Cockle Bay Park – Response to Agency Submissions

7.9 Temperature – after 15 minutes

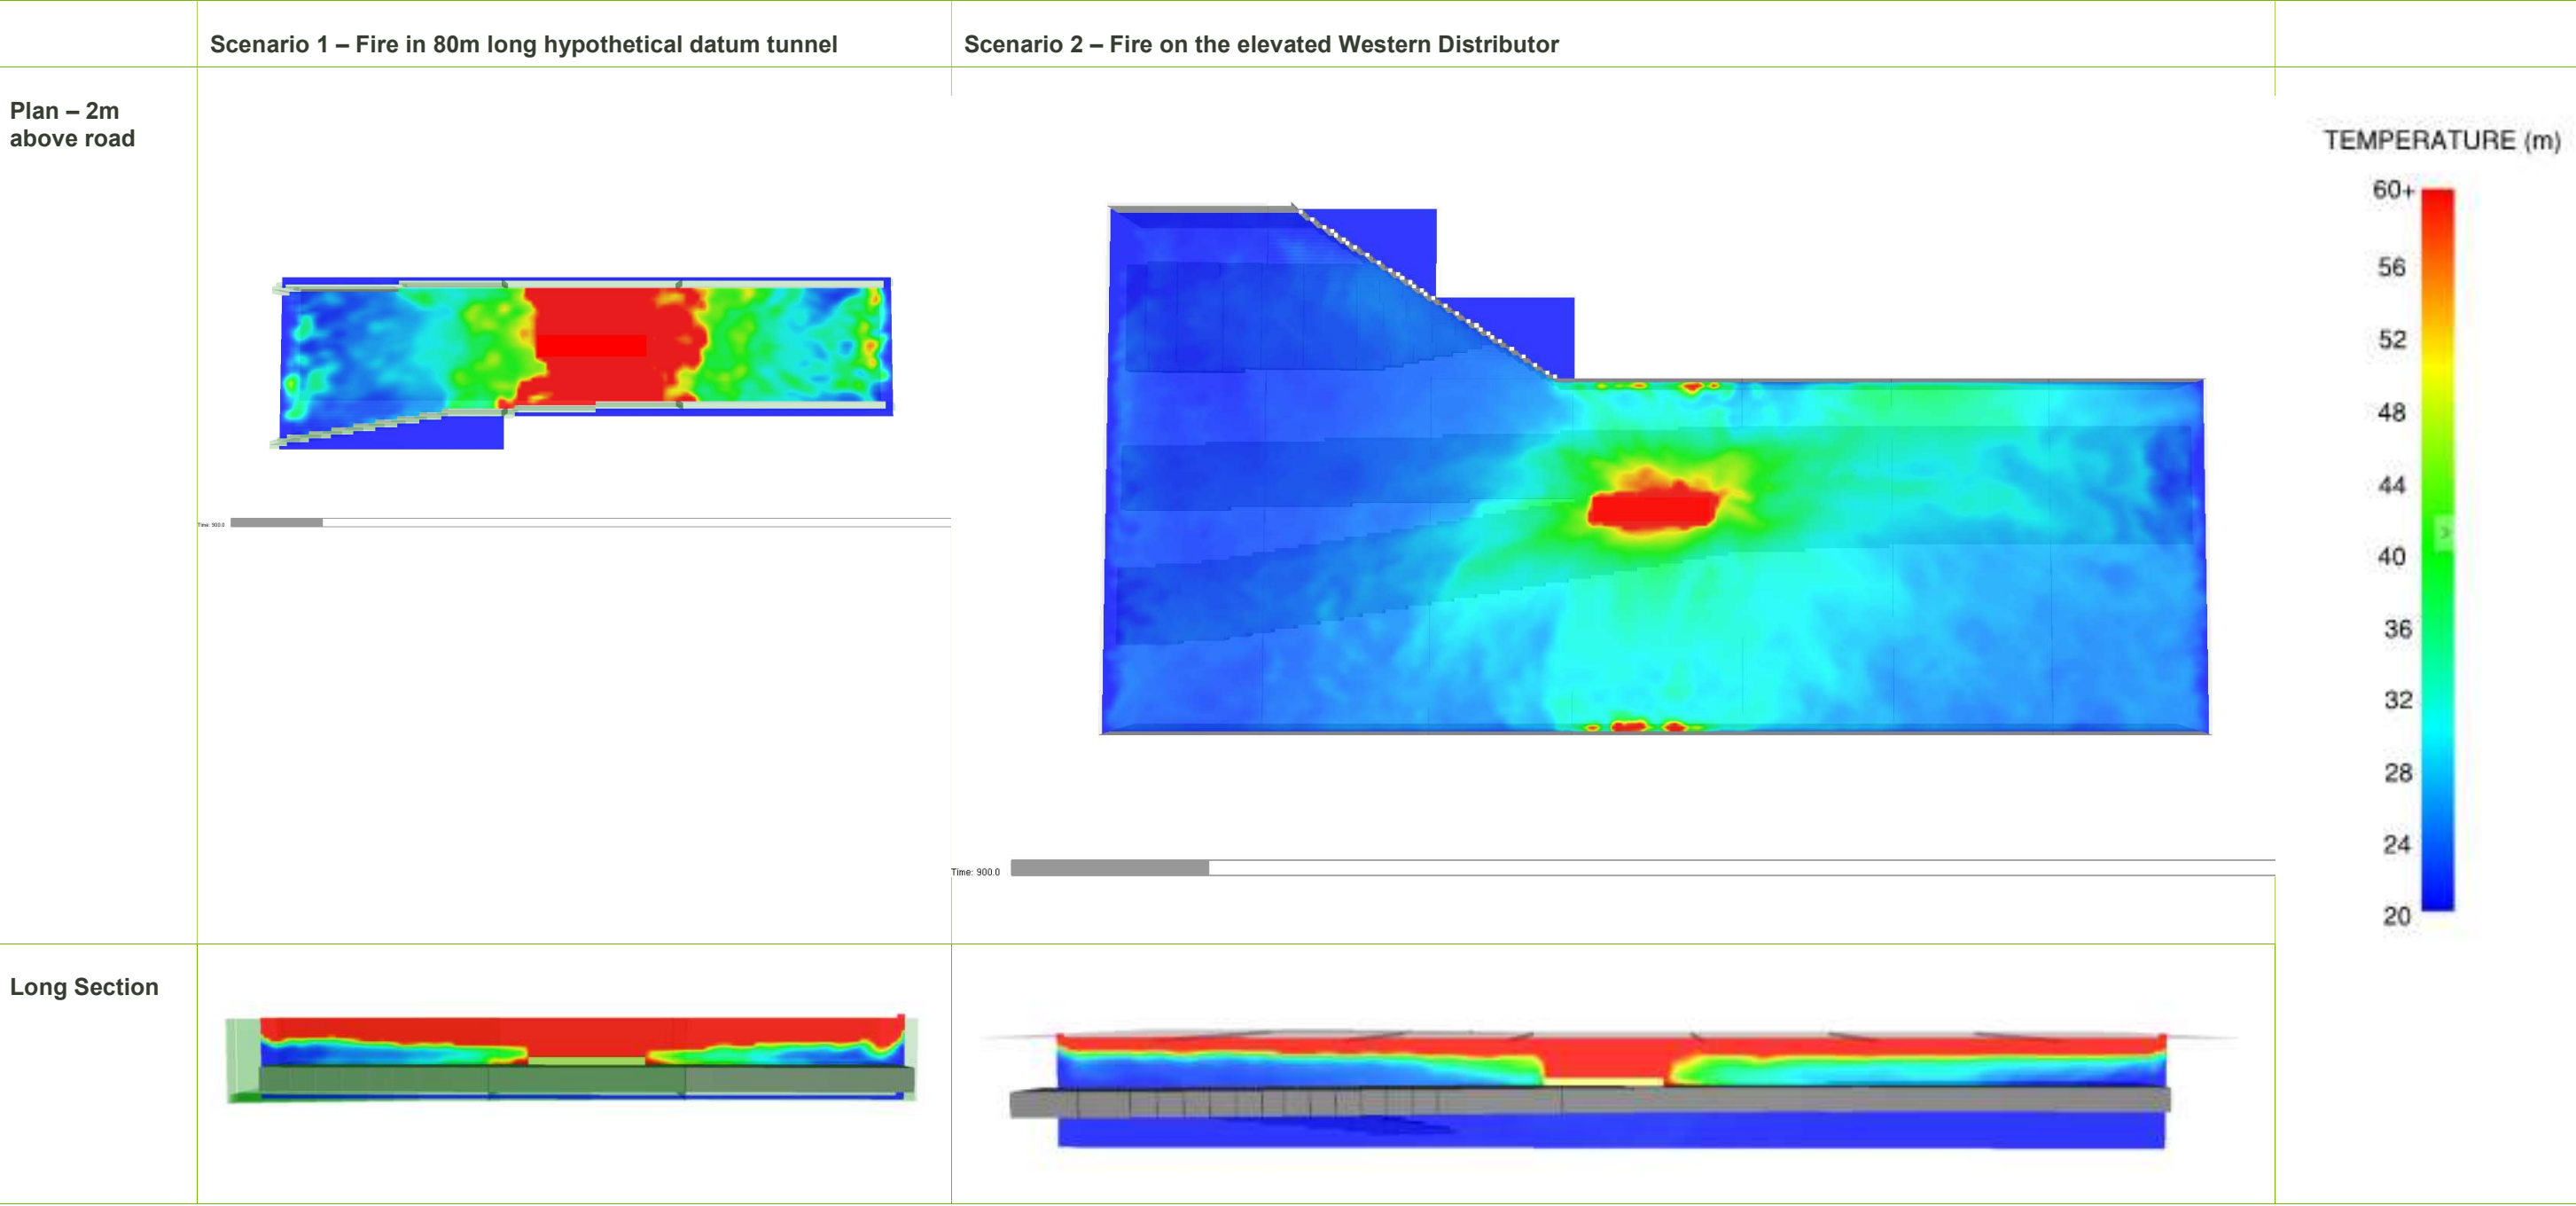
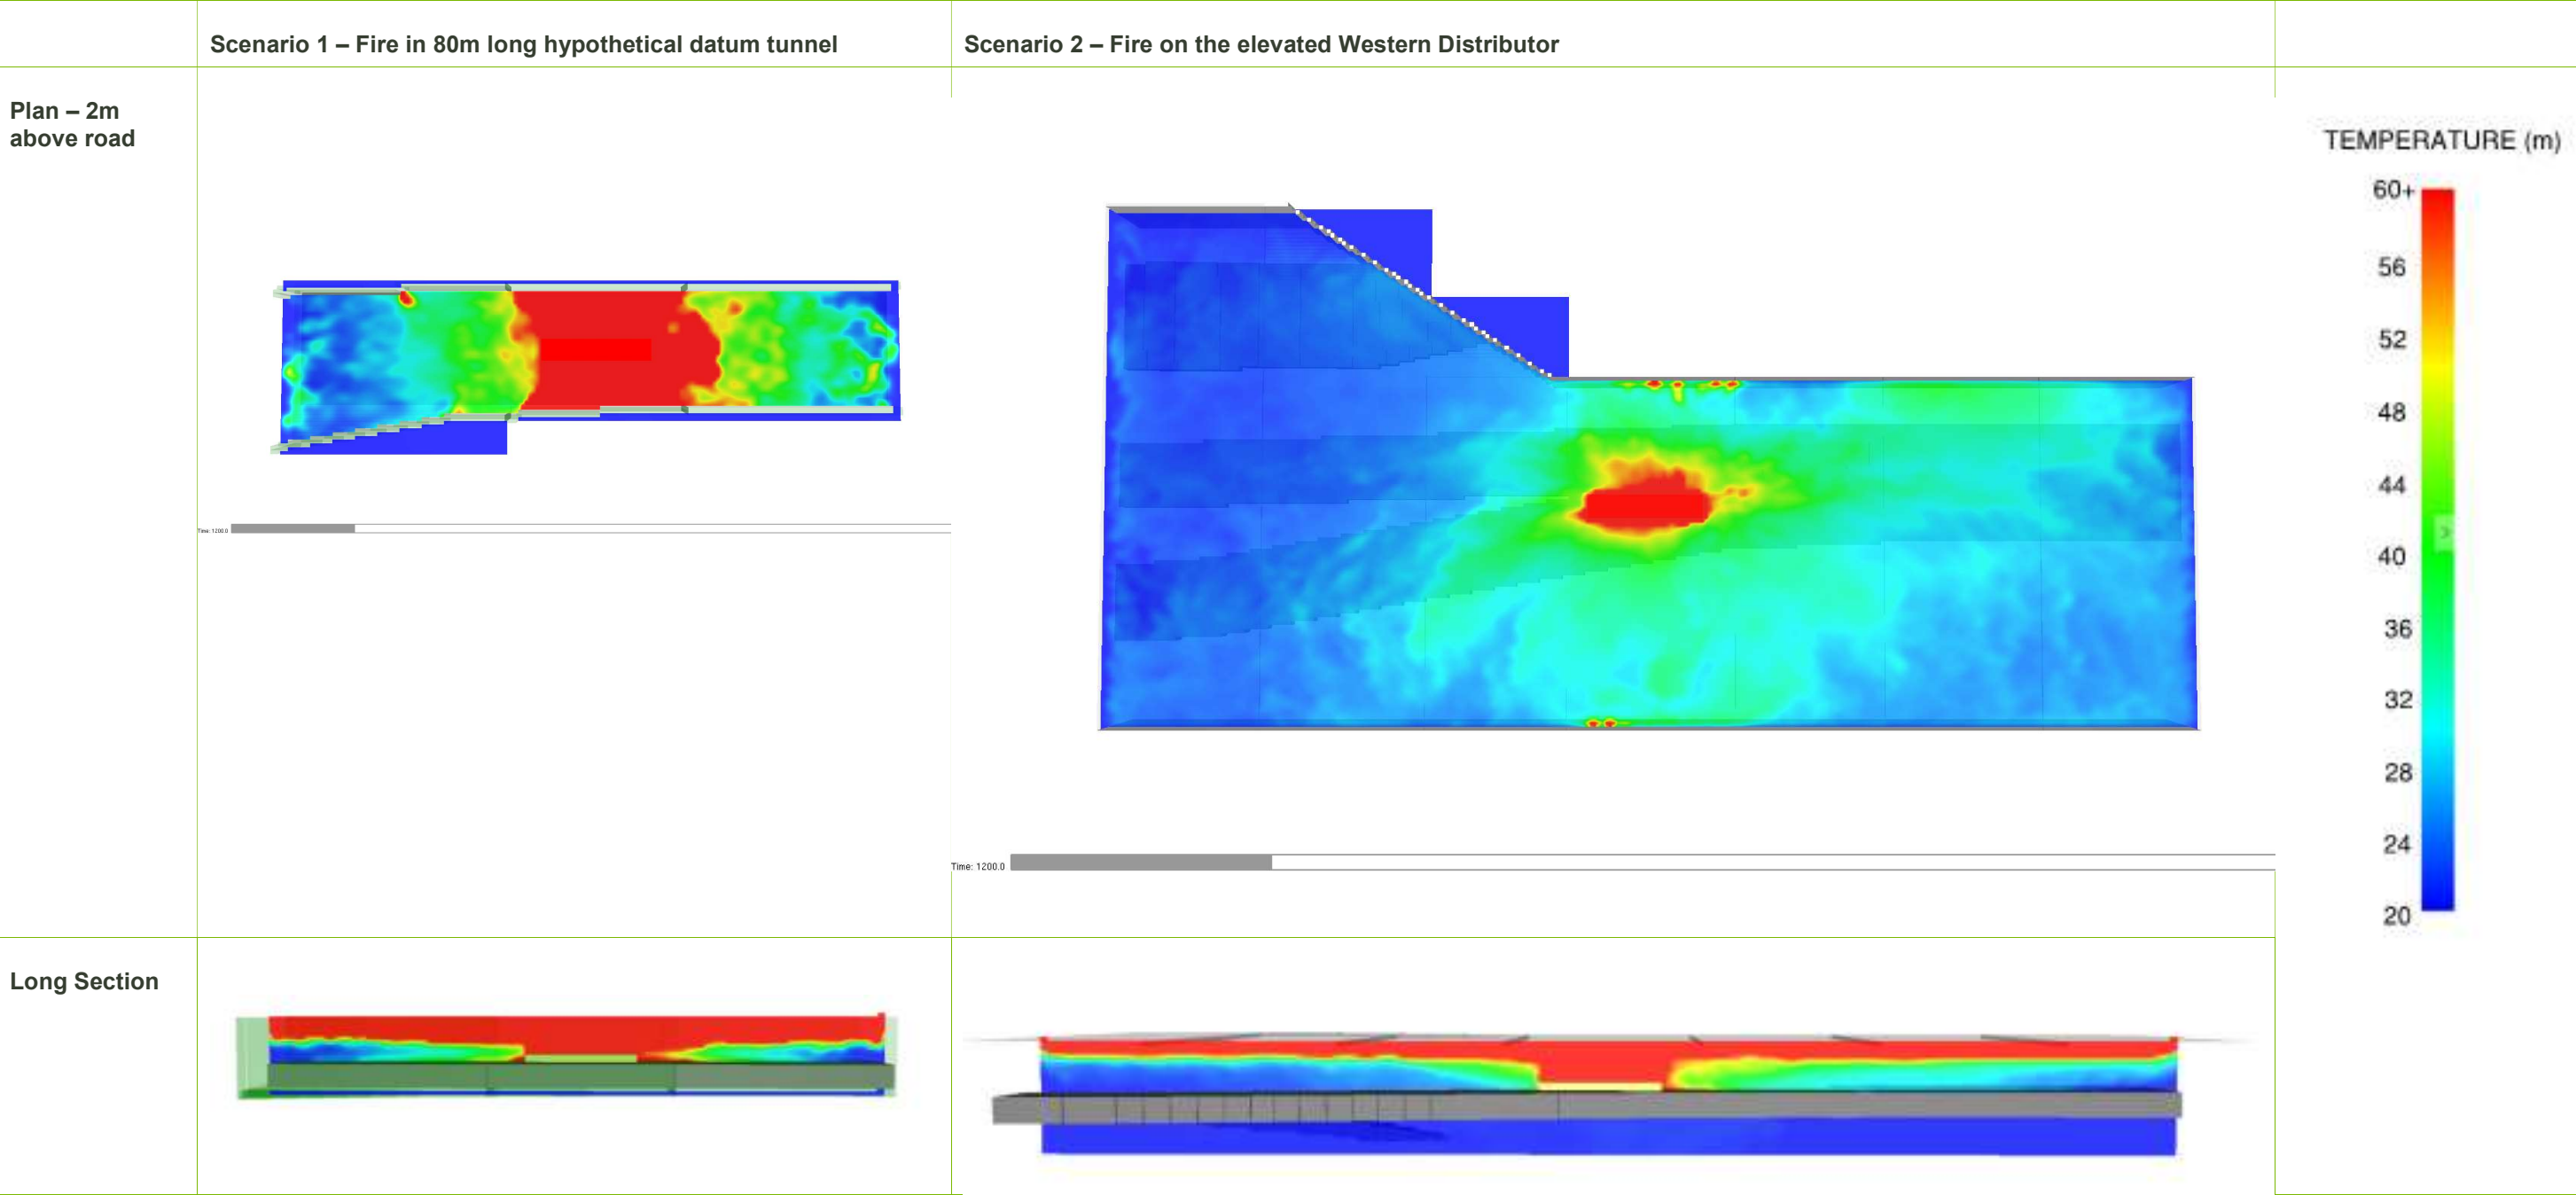
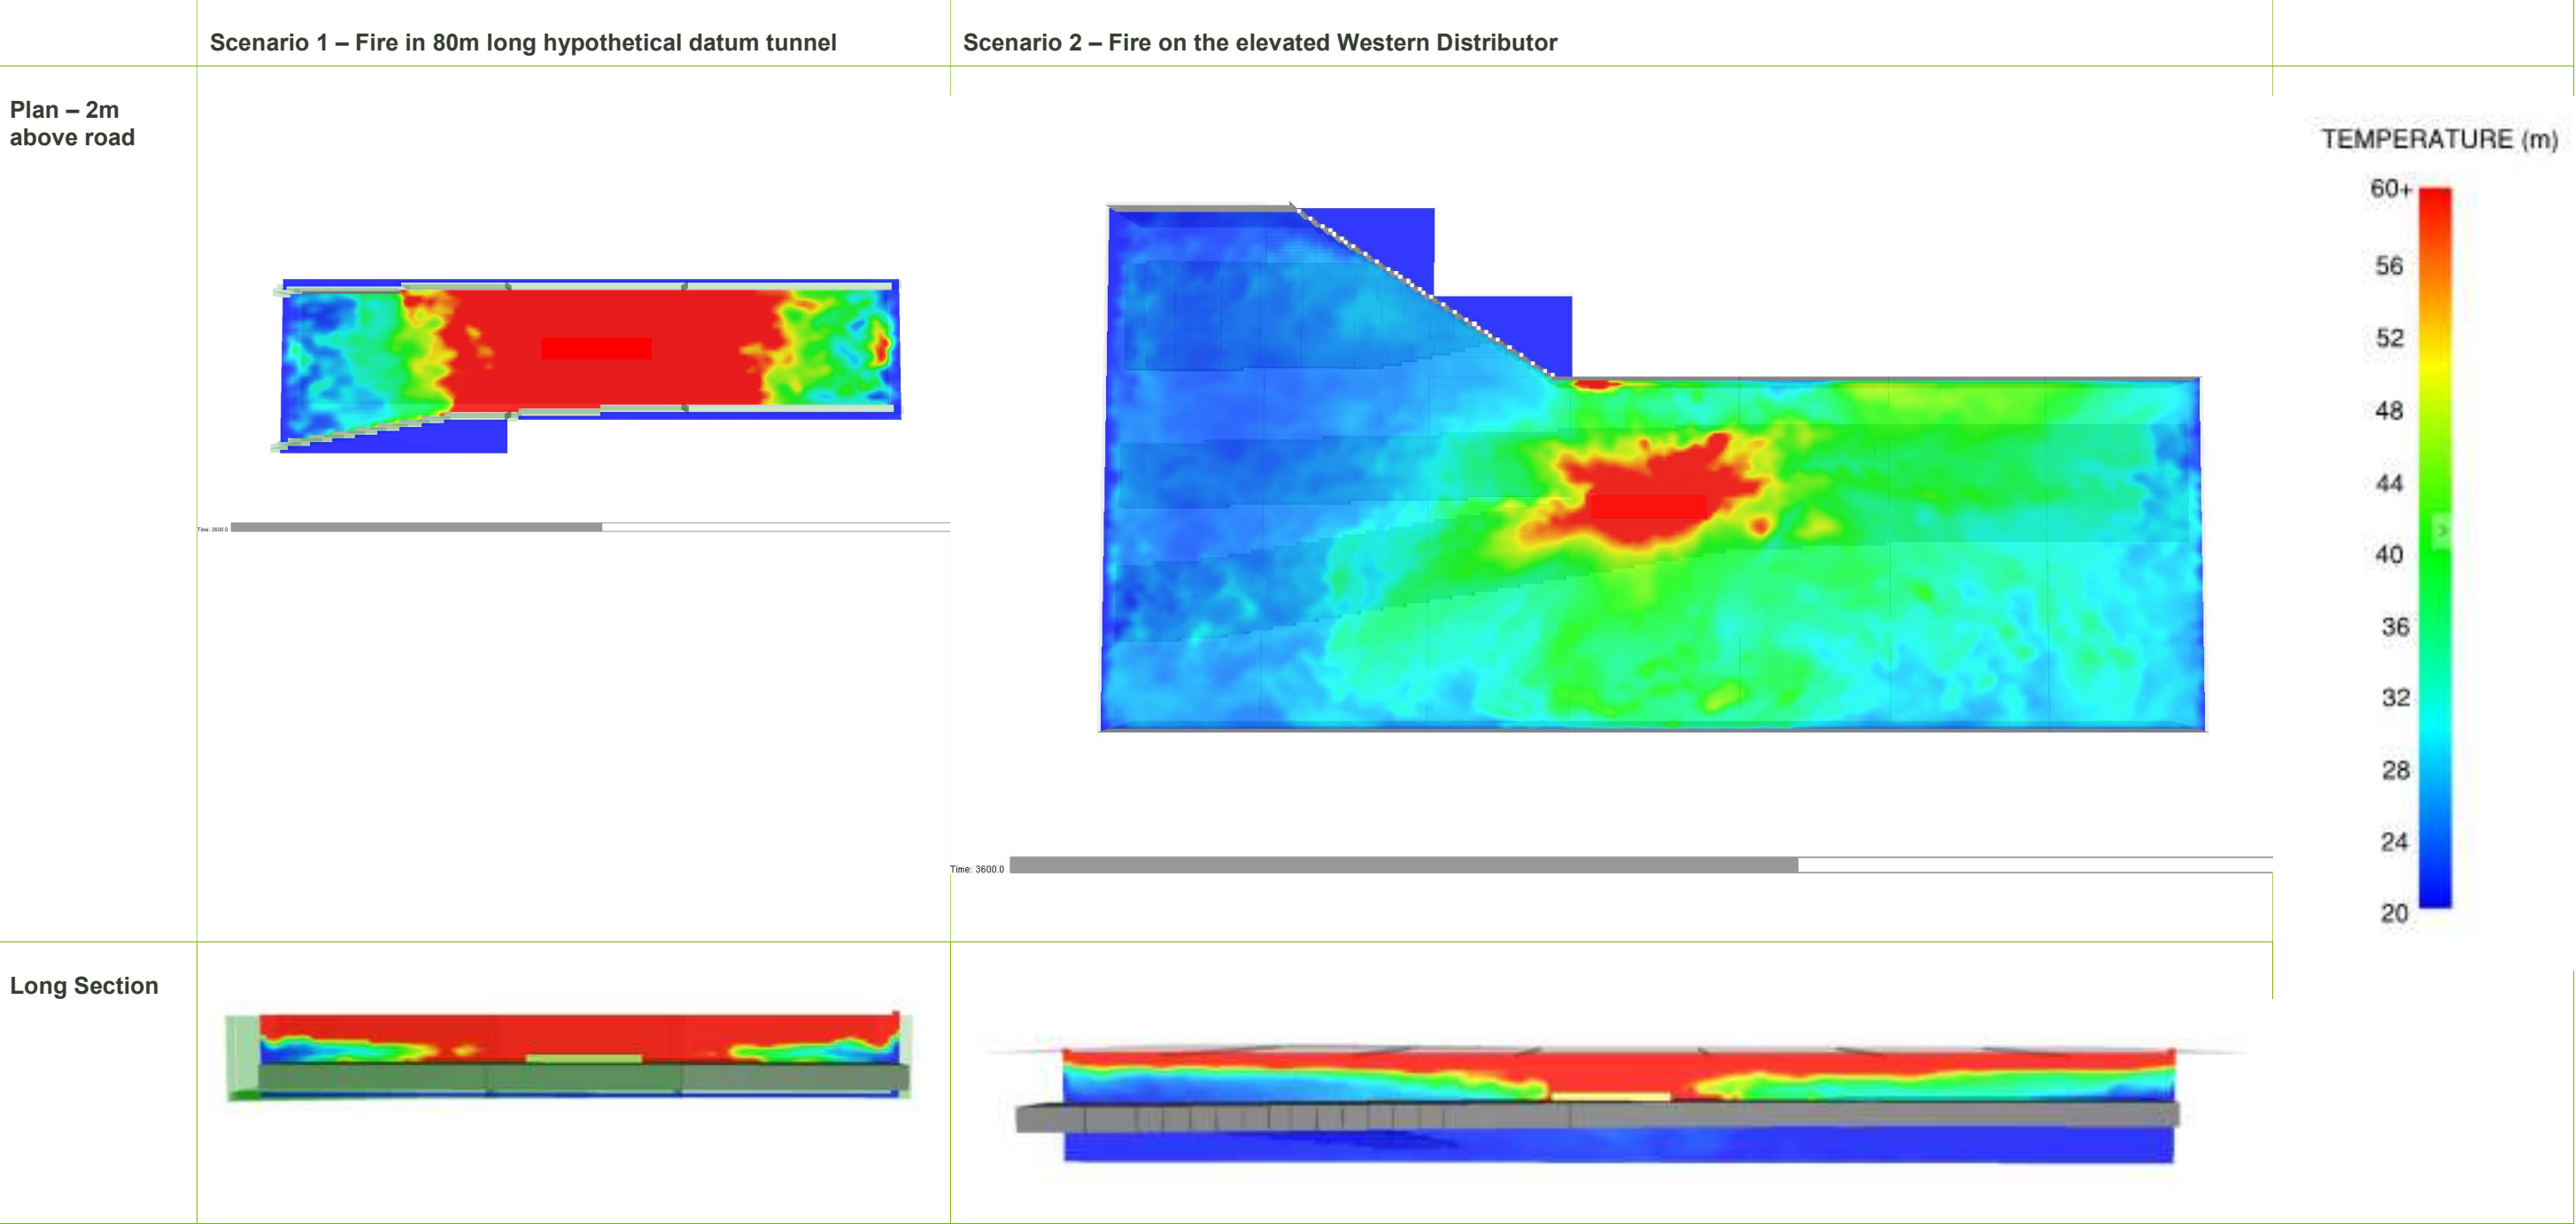
<p>Fire safety – the proposal has the effect of creating a tunnel underneath the podium – adequate provision of fire safety must be provided regarding traffic flow</p>	<p>Fire safety design criteria regarding the Western Distributor as it travels under the landbridge have been developed by Aurecon, in consultation with RMS (refer to Appendix J1). The design criteria are to be implemented at the relevant future stages of detailed design to ensure adequate fire safety provision is achieved.</p>
<p>Piering Options – RMS has request no piers in addition to the proposed piers option</p>	<p>Enstruct and Aurecon have considered structural options for landbridge pier locations including piers between on-grade northbound Harbour St and the elevated Western Distributor and an alternate 'no piers' option. The options are presented at Appendix K and Appendix W (refer to Section 7.20 of the</p>
